Application by Tillbridge Solar Limited for Tillbridge Solar Project
The Examining Authority's first written questions and requests for information (ExQ1)
Issued on 19 November 2024

Responses are due by Deadline 3: Tuesday 10 December 2024

## PLAN TITLE

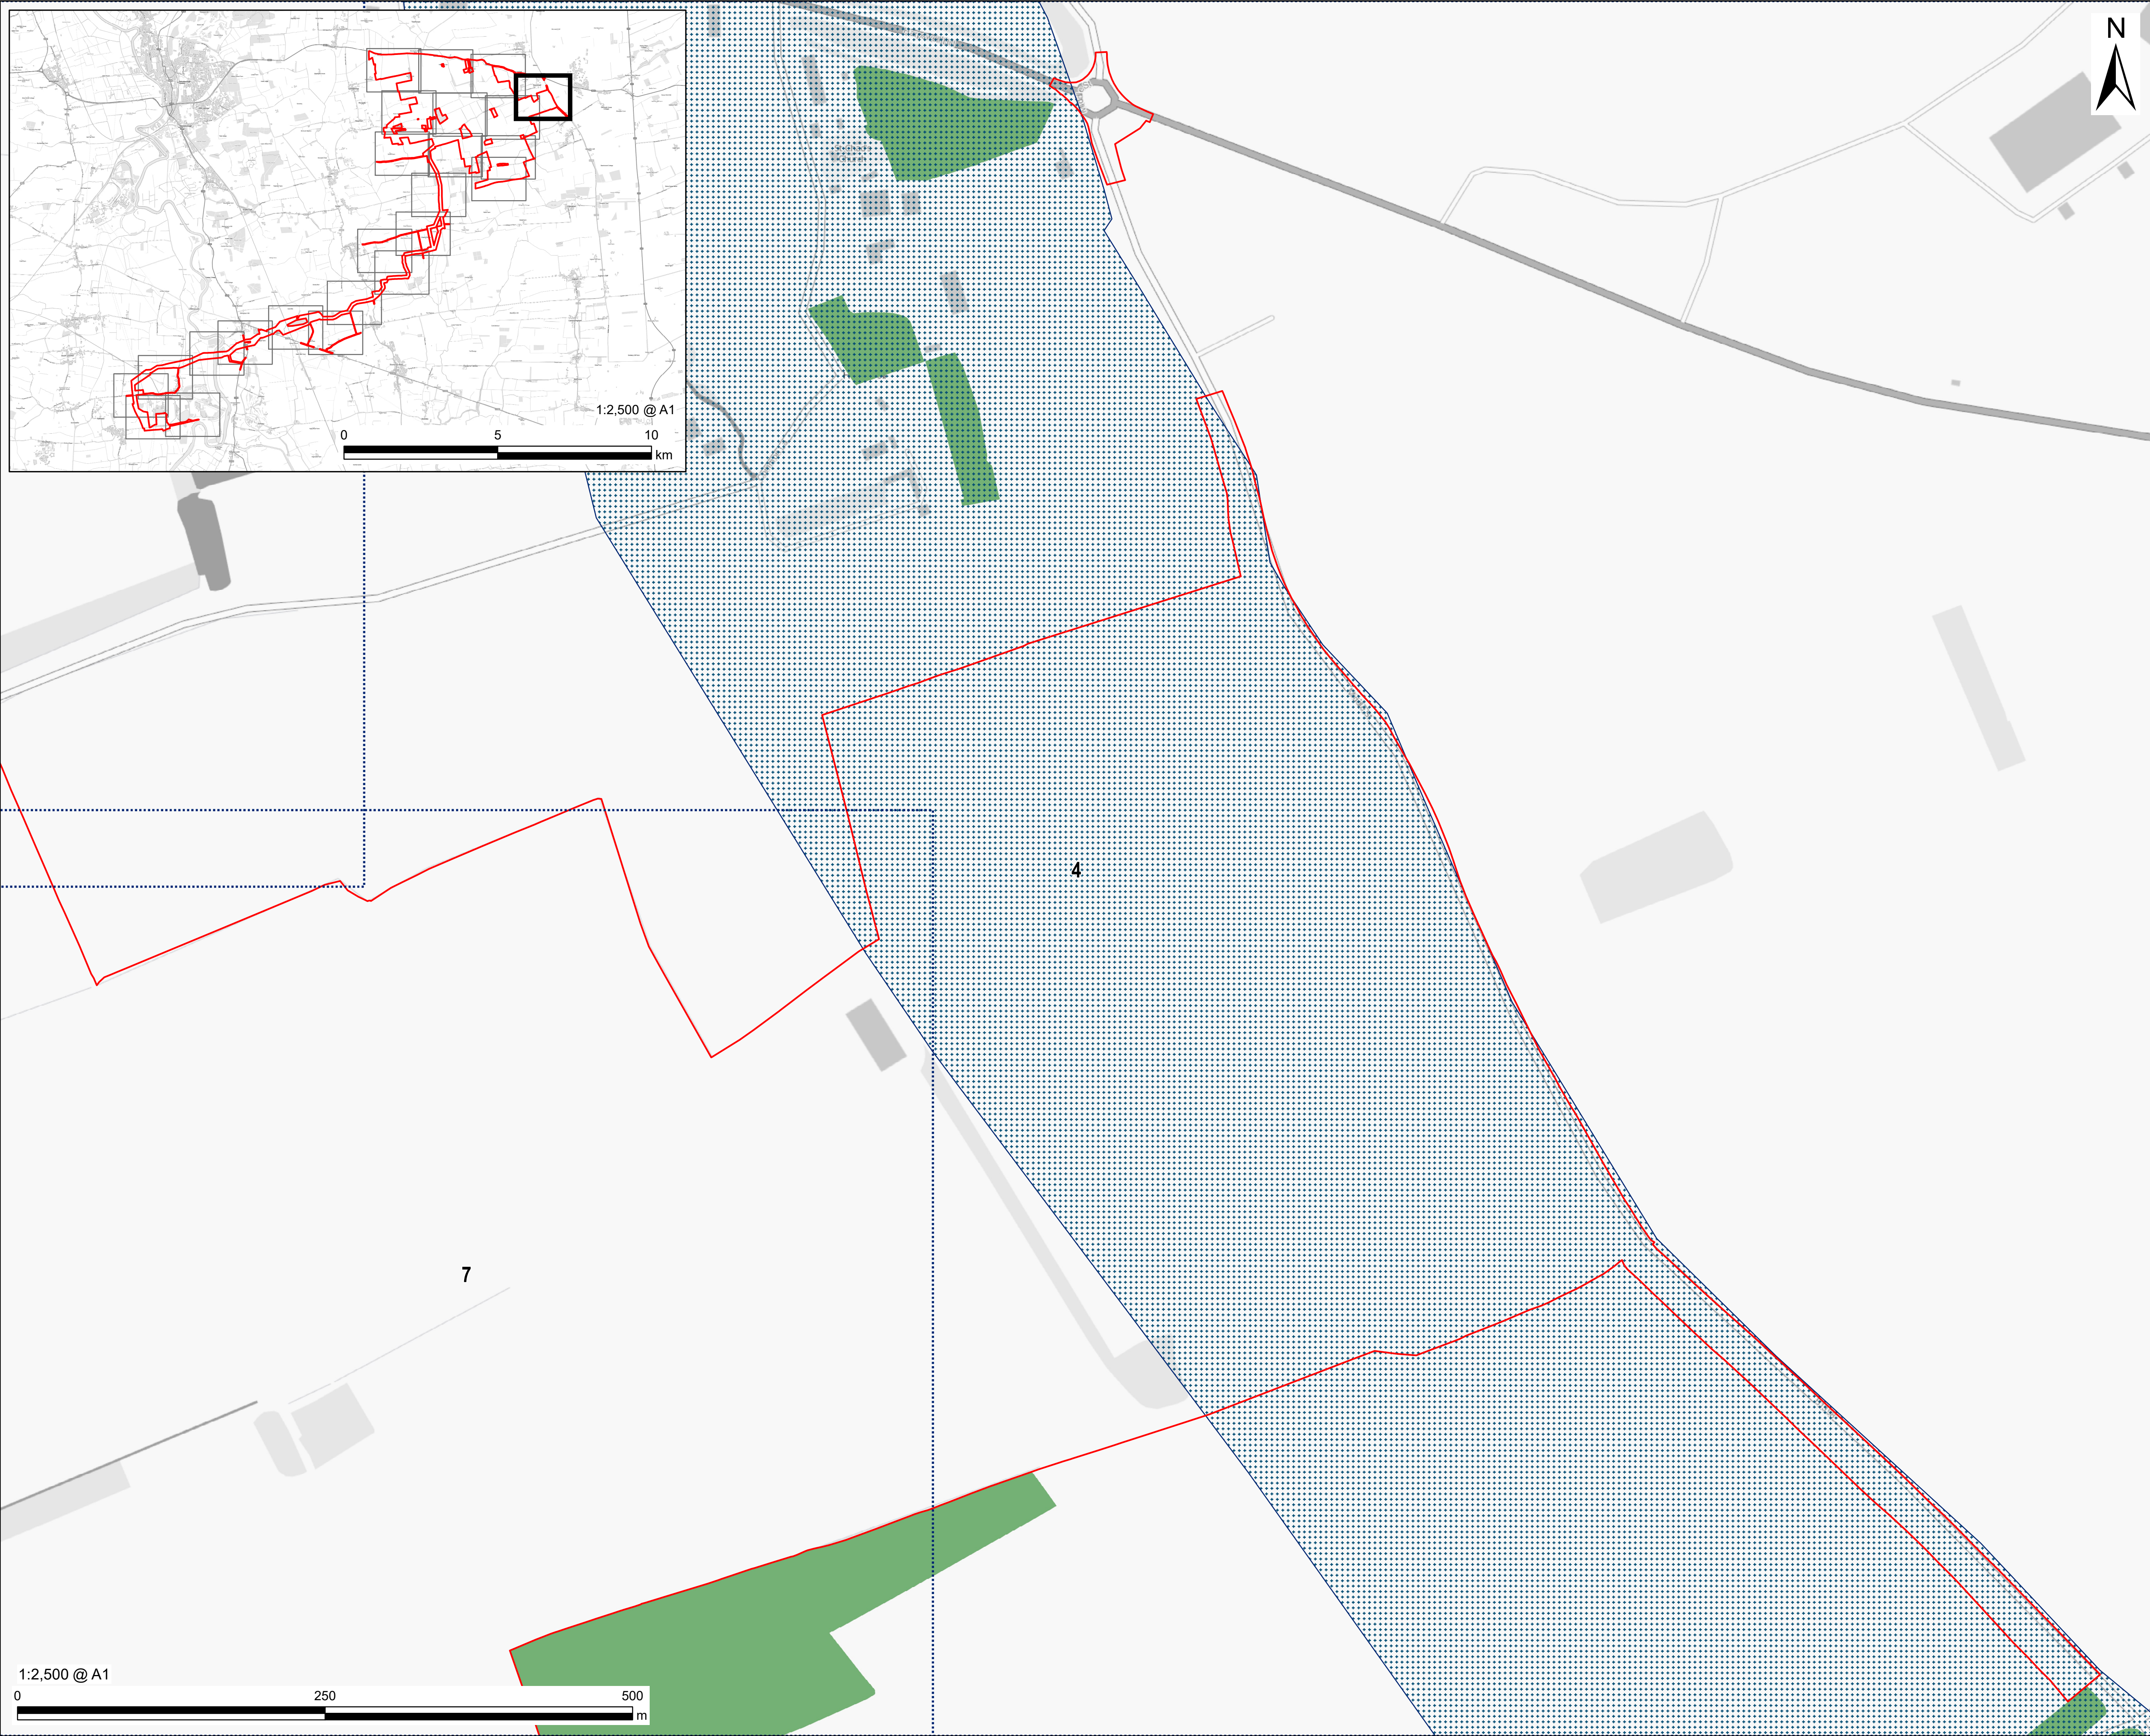
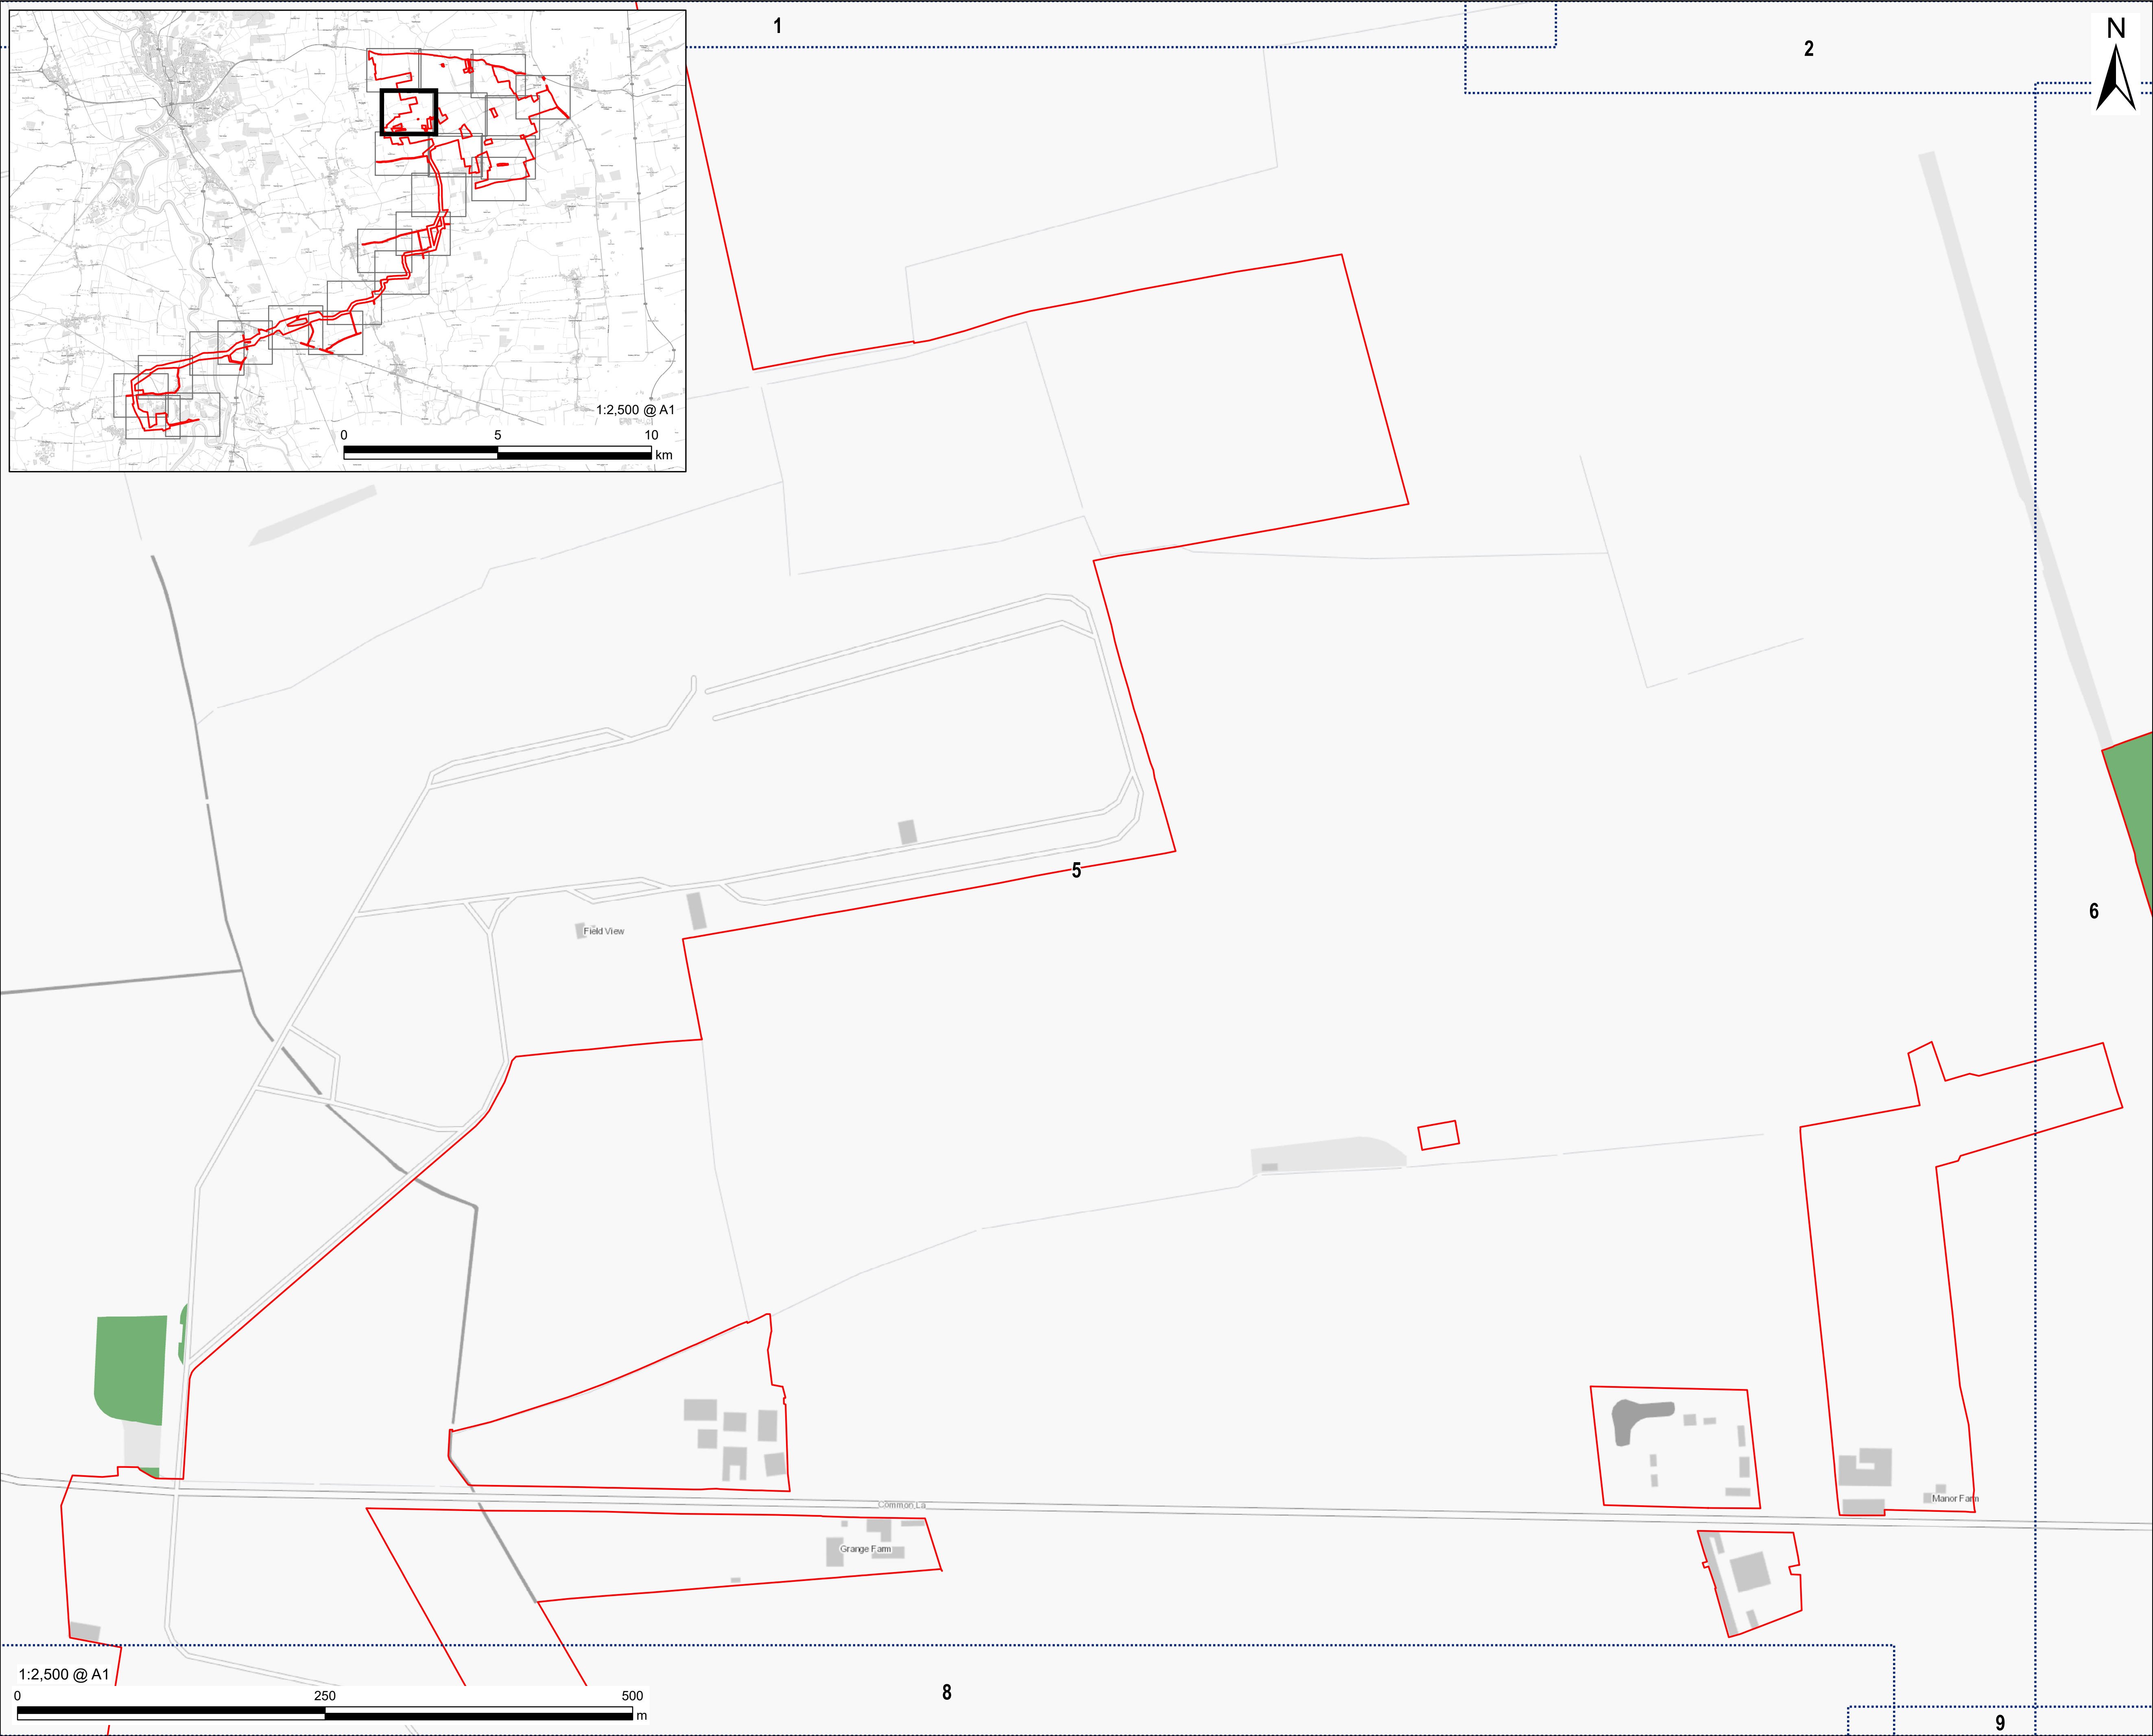
ExQ1	Question to:	Question:
		<p>please provide an updated copy of the phase 1 habitat maps depicted in ES Figure 9-3 [APP-166] which do not identify any target notes.</p> <p>Also please provide a plan demonstrating how the risks of a bentonite breakout during directional drilling would be managed and controlled.</p>
Habitats Regulations Assessment (HRA)		
Q1.2.14	Natural England	<p>HRA</p> <p>Does Natural England (NE) have any representations in relation to the Applicant’s responses to Natural England’s Relevant Representation [RR-208] provided in the document titled ‘Applicant’s Responses to Relevant Representations’ (PDF pages 10-28) [REP1-028]? Could NE also please provide a response on updated ES Appendix 9-12: Habitats Regulations Assessment Report [REP1-058] and in particular the conclusions in relation to:</p> <ul style="list-style-type: none"> a) the distances used to screen in European sites to the assessment; b) the rationale for screening out the Golden Plover qualifying feature of the Humber Estuary Ramsar site; c) conclusions in relation to no Likely Significant Effects (LSE) from water quality to the Humber Estuary Ramsar site and Humber Estuary Special Area of Conservation (SAC); and d) the conclusions in respect of in-combination effects with the One Earth Solar and Great North Road solar projects.
